MECKLENBURG COUNTY  
Park and Recreation Department

MEMORANDUM

**DATE:** March 26, 2024

**RE:** Rezoning Petition #2024-031  
PID#07328101

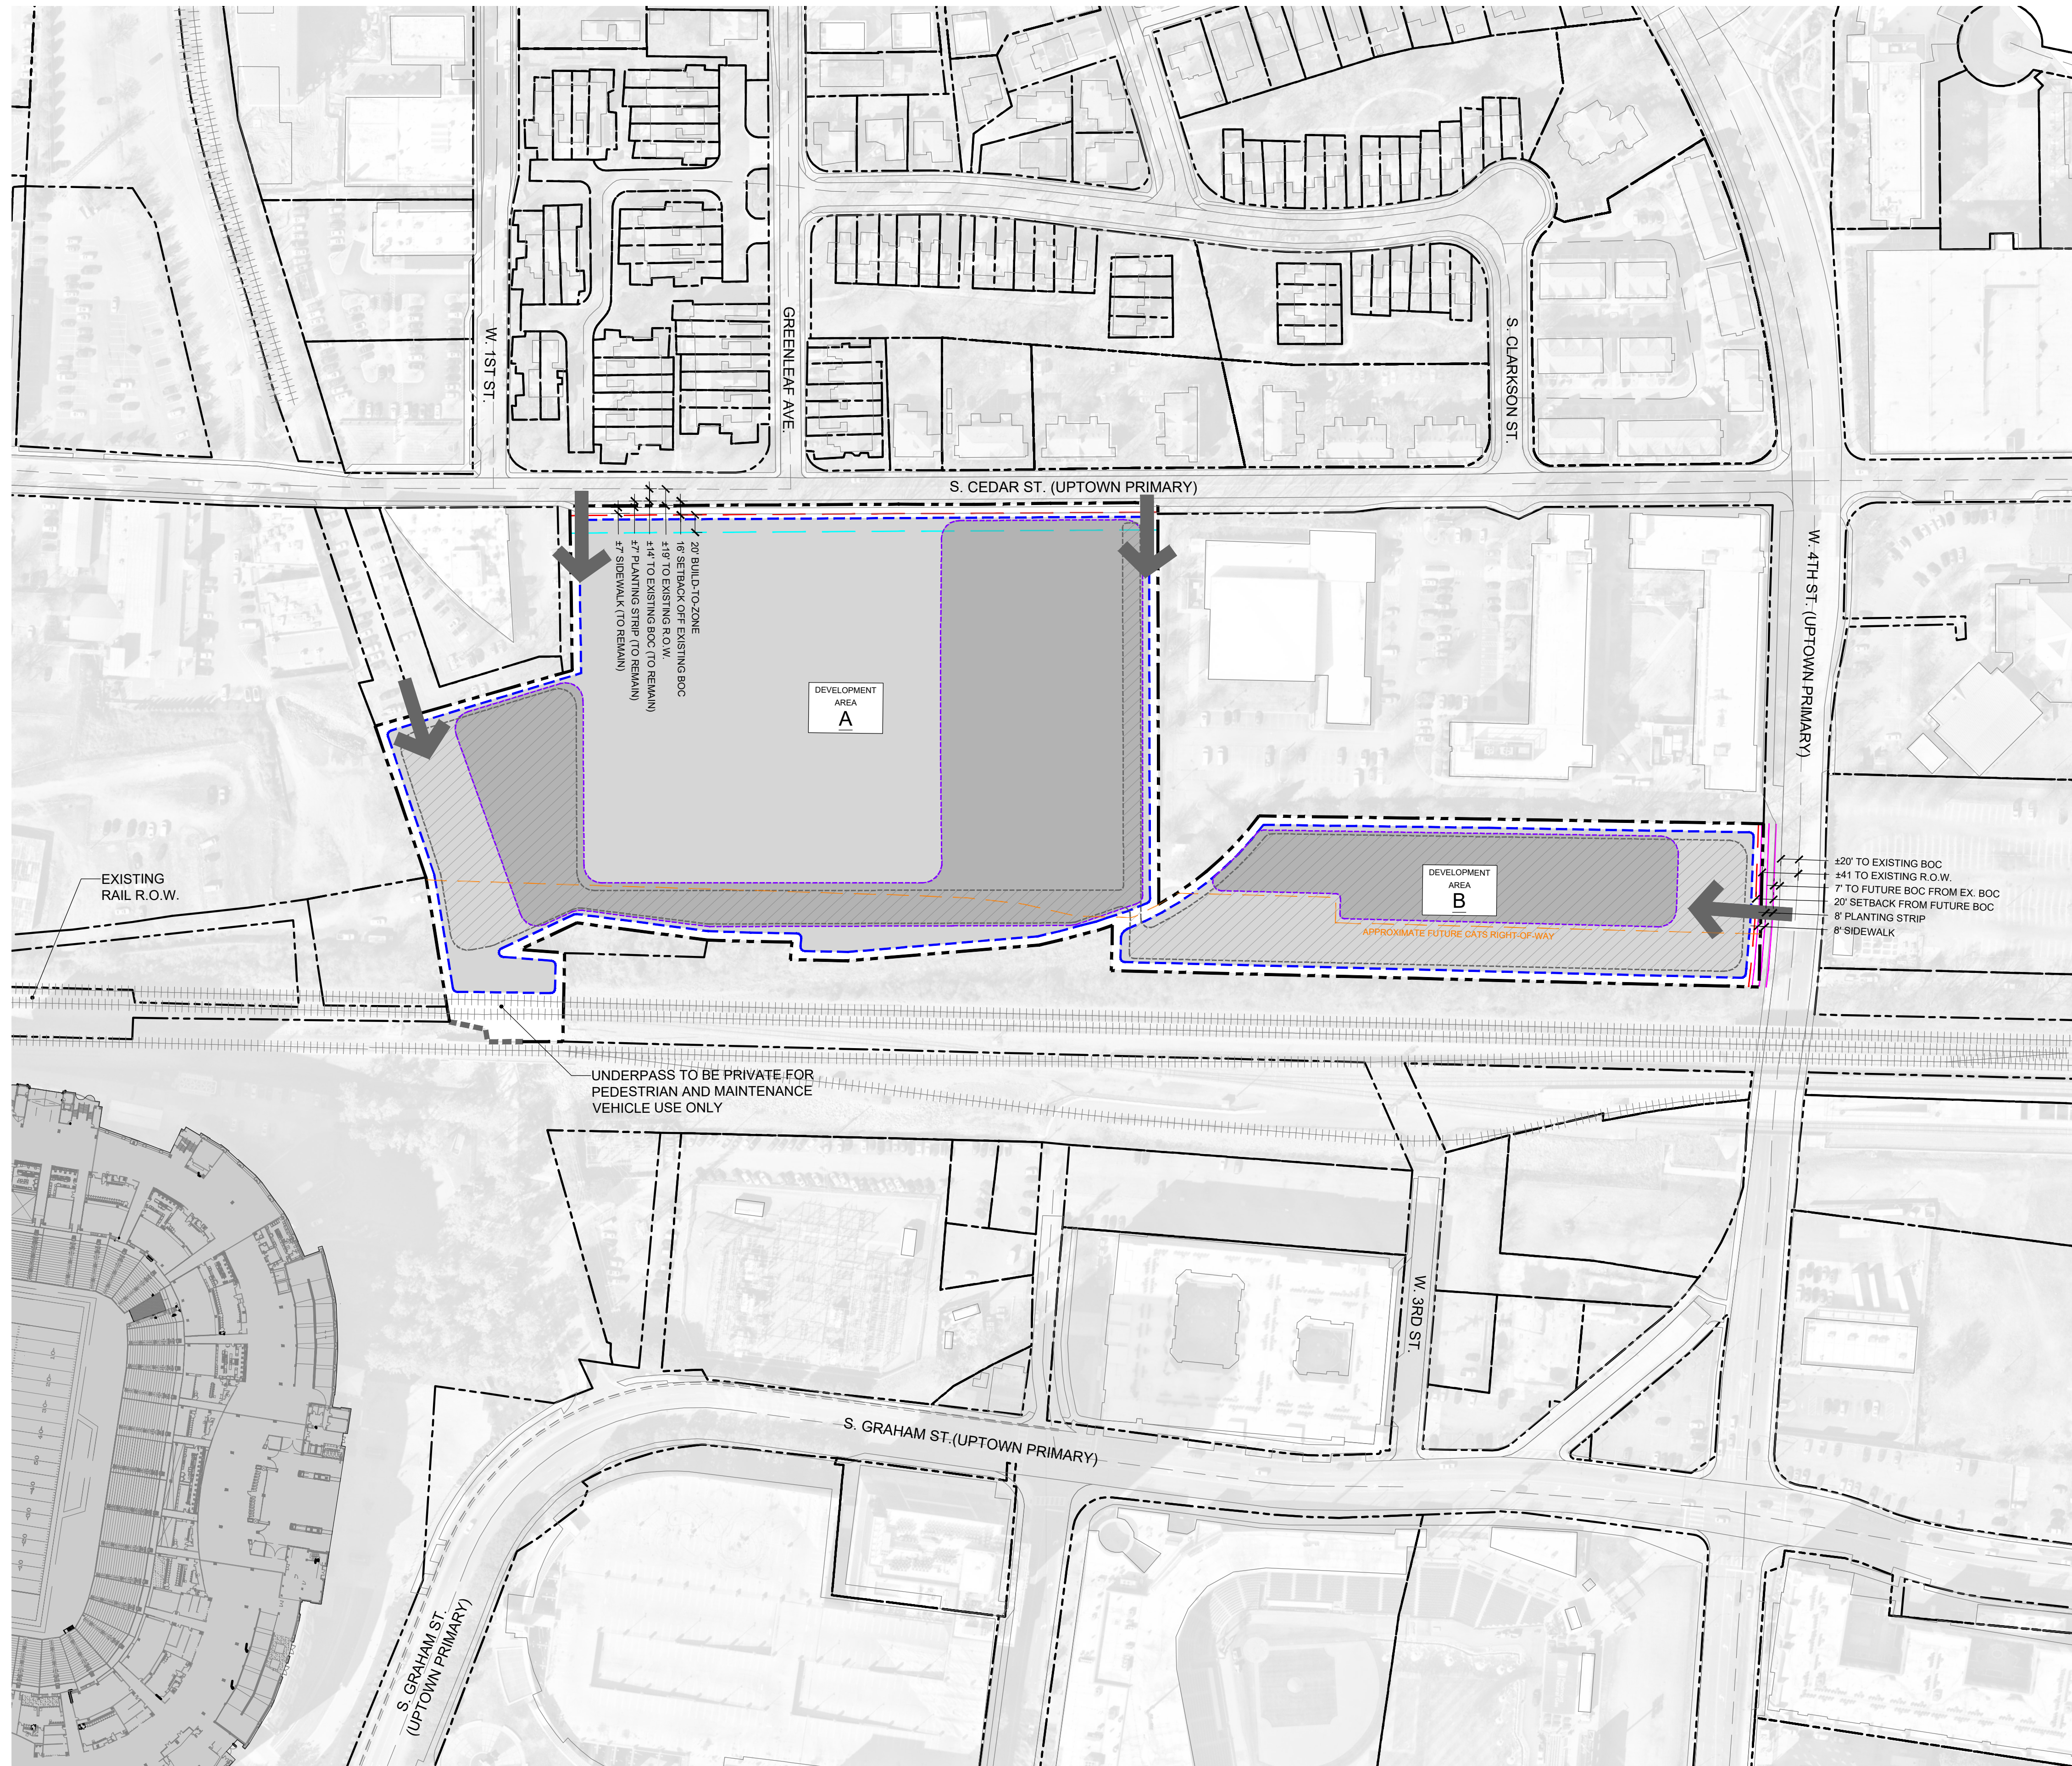
MCPR requests that the shared use path between Graham Street and Cedar Street always remain open for access and connectivity, and not be closed for events. If impacts to the shared use path occur during construction, please provide a pedestrian detour.
